Re: Little Stars Day Care
1500 Coors Blvd NW
Traffic Circulation Layout
Architect's Stamp 04-13-2022 (L11-D045)

Based upon the information provided in your submittal received 04-14-2022, the above referenced plan cannot be approved for Building Permit until the following comments are addressed:

TRAFFIC CIRCULATION LAYOUT

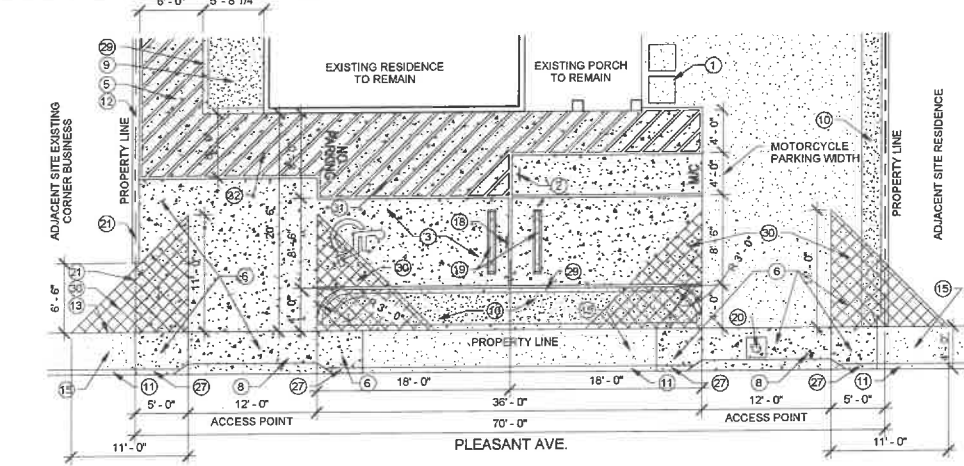
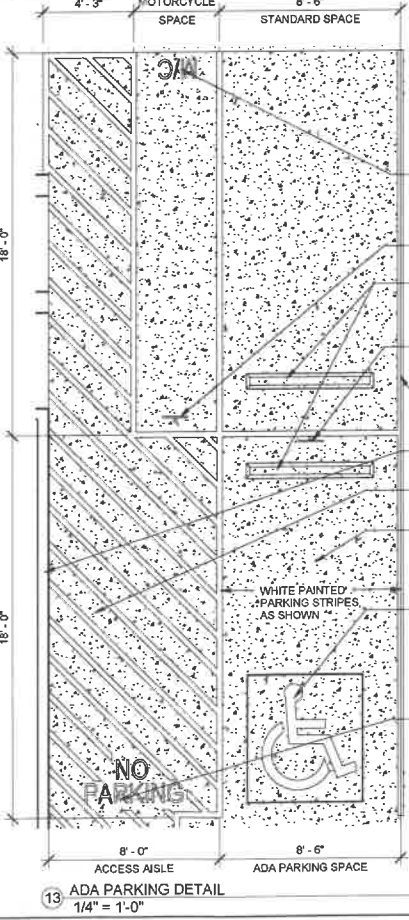
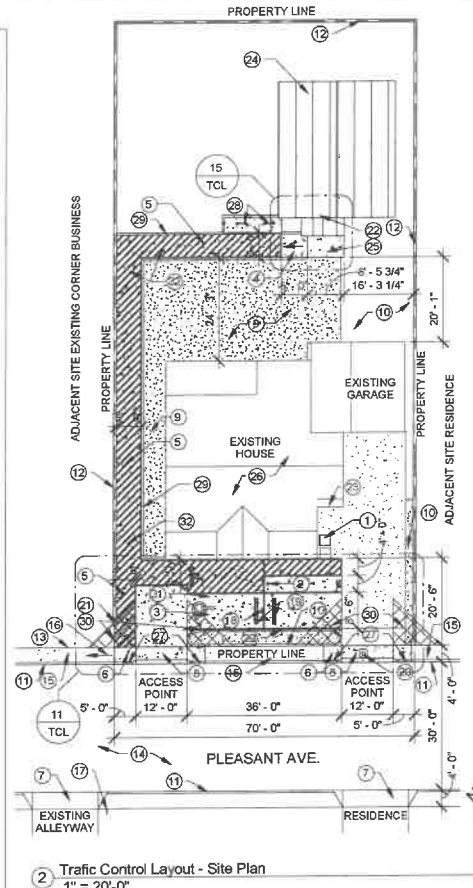
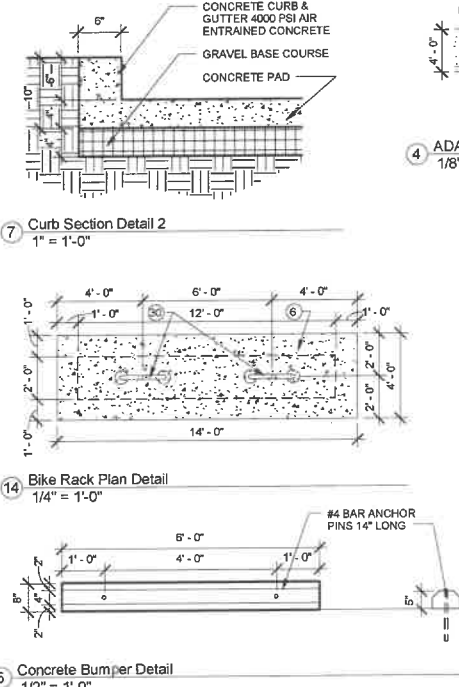
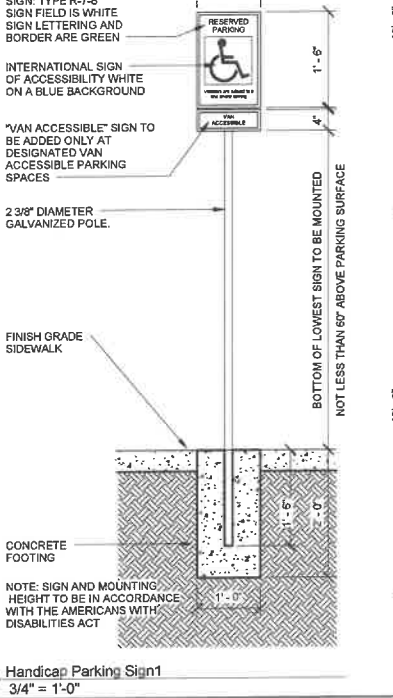
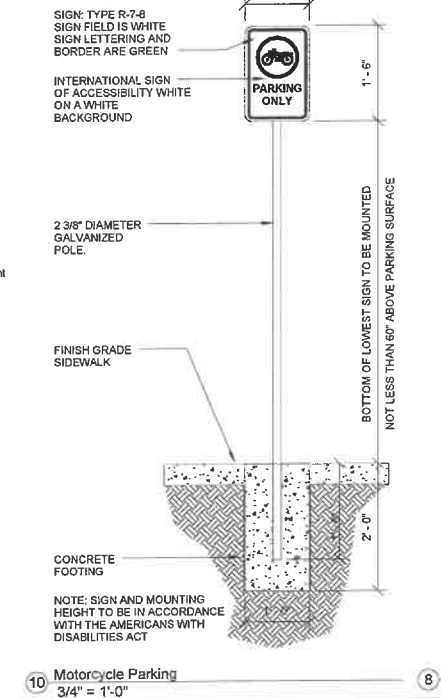
1. Corrdination with NMDOT is required for any type of Development fronting their ROW/roadway (Coors).
2. Listed are the number of parking spaces required by the IDO as well as the proposed number of parking spaces including **bicycle and motorcycle parking.**
Coordinate/discuss with Zoning.

3. Hanover existing Public Sidewalk: It appears, from you design, a partial width of sidewalk is located outside of public ROW. This will require a Sidewalk Easement.

4. **Keyed Note 1:** The existing land and ramp will need to comply with the most current/updated ADA accessibility requirements. Please verify this is the cause.

5. **Keyed Note 3:** Reference sheet for location of detail. You just have XXXx for sheet number.
6. **Keyed Note 11:**
 - Drivepad will need to be current/updated ADA accessible and it appears that this existing drivepad condition is not. Please provide a more current design.

- Your note is confusing since the drivepad is located on Hanover but the note specifies Coors. Please clear up this note.
7. **All existing public sidewalk:** Provide existing widths.

8. **Private sidewalk dimensions:** Some dimensions are not shown on layout. Please provide dimensions.
9. **Detail 3:**
 - Where is your 50:1 max landing. Please label on detail.

- Shown is 12:1 max but on TCL layout it needs to be shown.
10. **Keyed Notes:** All references need to be provided or take out the XXX and call out this sheet.

11. Please identify all existing buildings, doors, structures, sidewalks, curbs, drive pads, wall and anything that influences the parking and circulation on the site.
12. Identify the **right of way width**, medians, curb cuts, and **street widths** Coors and Hanover.
13. Maximum access **width** for arterial, collector, and **local streets** are as follows:

14. Provide existing drivepad width (Not shown).
15. Please list the width and length for all existing and proposed parking spaces. Some dimensions are not shown.
16. **The minimum parking stall dimensions are:**

17. Motorcycle parking spaces shall be designated by its own conspicuously posted upright sign, either free-standing or wall mounted per the zoning code. Label pavement MC.

21. Bicycle parking spaces shall be at least 6 feet long and 2 feet wide.
22. A 5 ft. keyway is required for dead-end parking aisles.
23. Per the DPM, a **6 ft. wide** ADA accessible pedestrian pathway is required from the public sidewalk to the building entrances. Please clearly show this pathway and provide details.

24. Per DPM, a **6 ft. wide** ADA accessible pedestrian pathway is required from the ADA parking stall access aisles to the building entrances. Please clearly show this pathway and provide details.

25. Fire Department: An approval Fire 1 plan needs to be provided. Since the addition of more parking stalls has compromised the turn around for FD trucks.

26. **Drive Aisle and Parking Area:** A hard driving surface will be required as part of this proposed project for parking area and drive aisles. Provide concrete design for ADA parking stalls and access aisle.

27. Please provide a sight distance exhibit
28. Show the clear sight triangle and add the following note to the plan: "Landscaping and signage will not interfere with clear sight requirements. Therefore, signs, walls, trees, and shrubbery between 3 and 8 feet tall (as measured from the gutter pan) will not be acceptable in the clear sight triangle.

30. Add a note stating "All broken or cracked sidewalk must be replaced with sidewalk and curb & gutter." A build note must be provided referring to the appropriate City Standard drawing (2430 & 2415A).
